DECISION DELEGATED TO HEAD OF PLANNING

Application No: H09-0638-24 **Applicant:** Lincolnshire County Council

Proposal: Siting of 1 V Sign and 3 Small Hoarding Signs

Location: Plot 2 The Hub Cibus Way Holbeach

Post Mounted Panel Sign - Double Sided - Isometric
Triple C Mount Rail

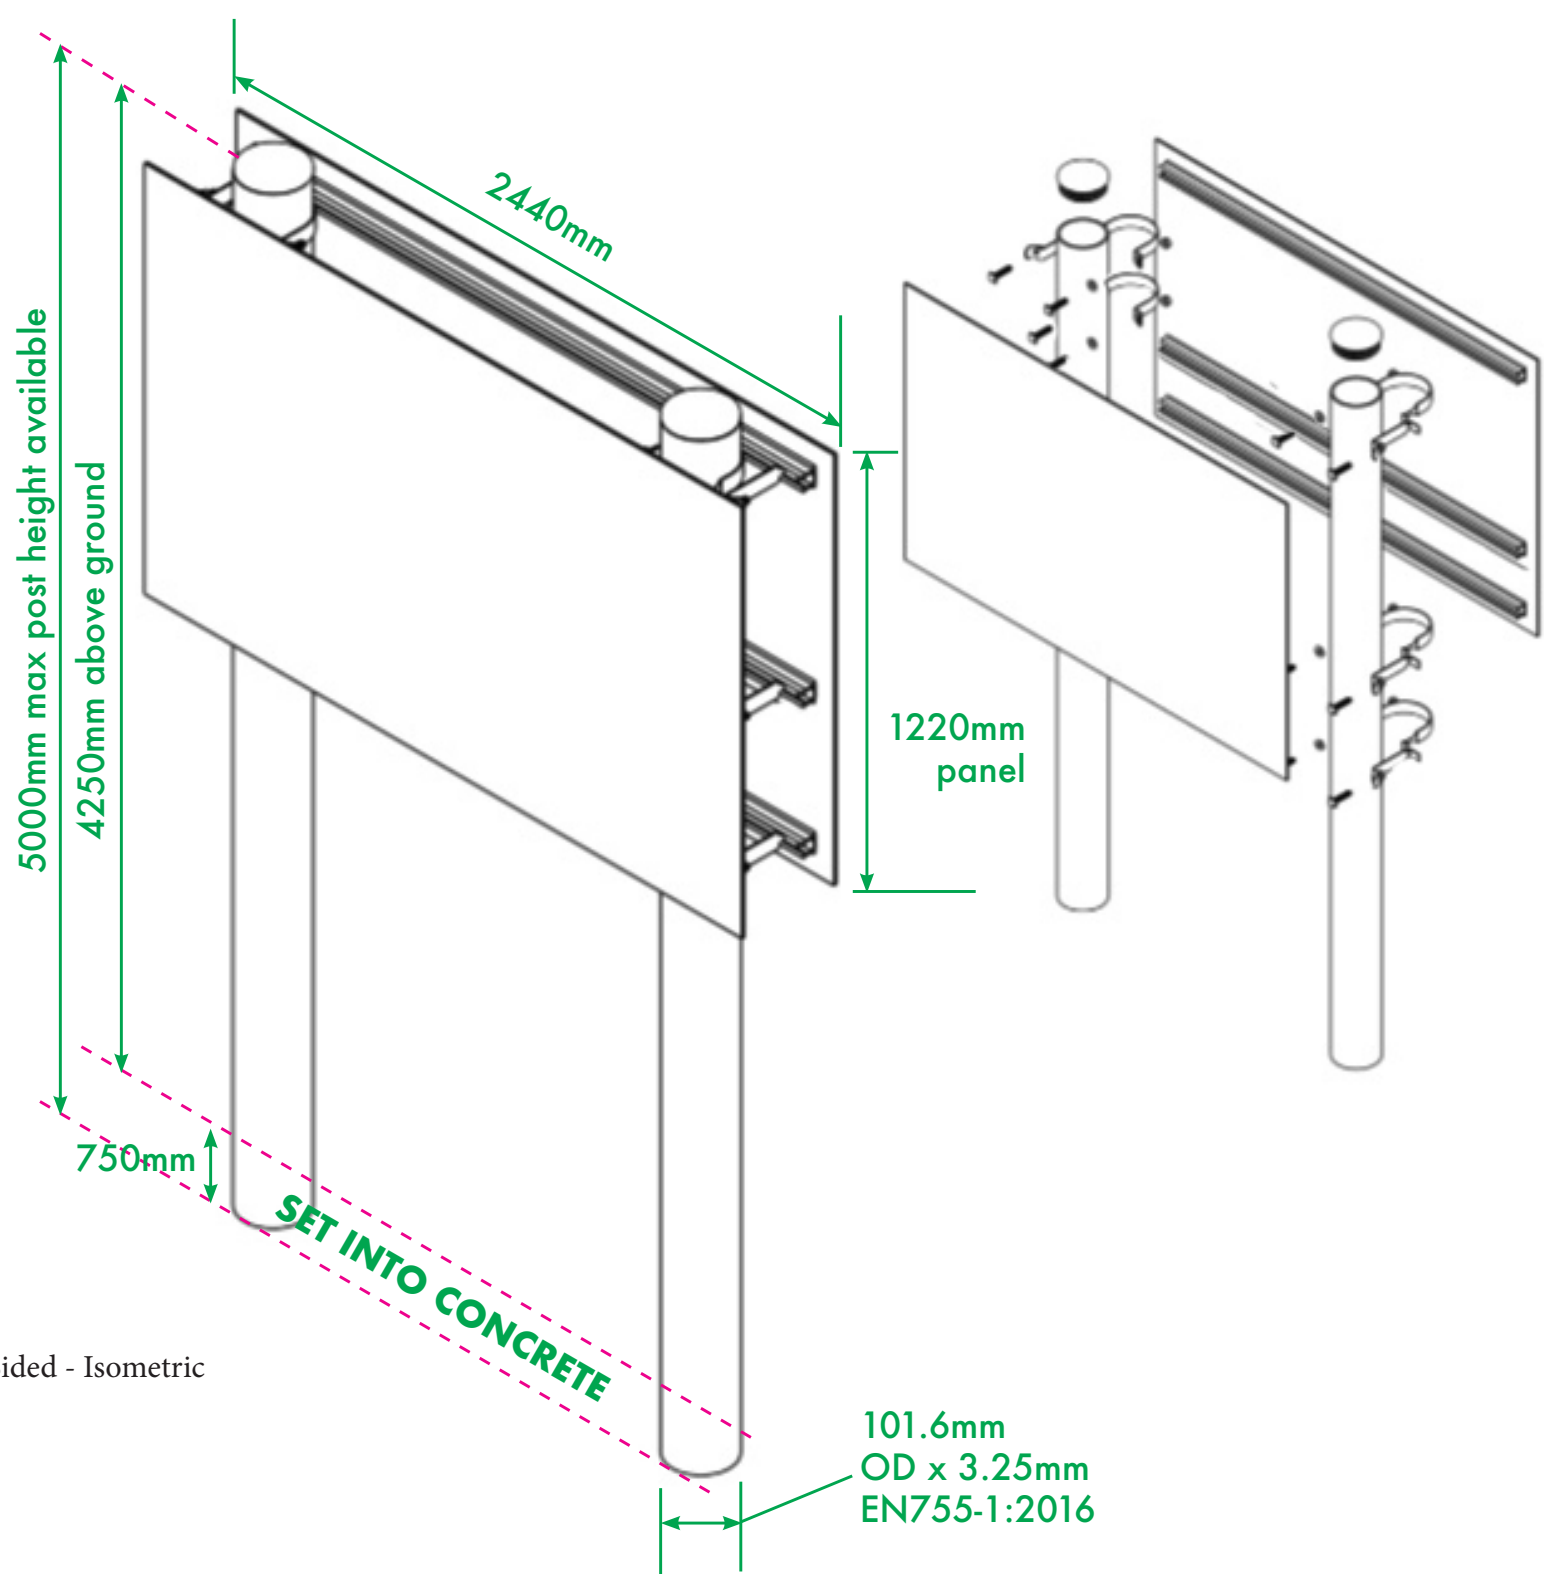
"Additional information required: How far back from the carriageway edge will the hoarding sign be located off the A17?"

Comments: The proposal is for the Siting of 1 V Sign and 3 Small Hoarding Signs. The signs are located in land owned by Lincolnshire County Council the signs located off the A17 are set well back within field and will not have a detrimental impact on the public highway. I am happy that the position of the V sign will not have a detrimental impact on the public highway - it will not obstruct visibility at the roundabout."
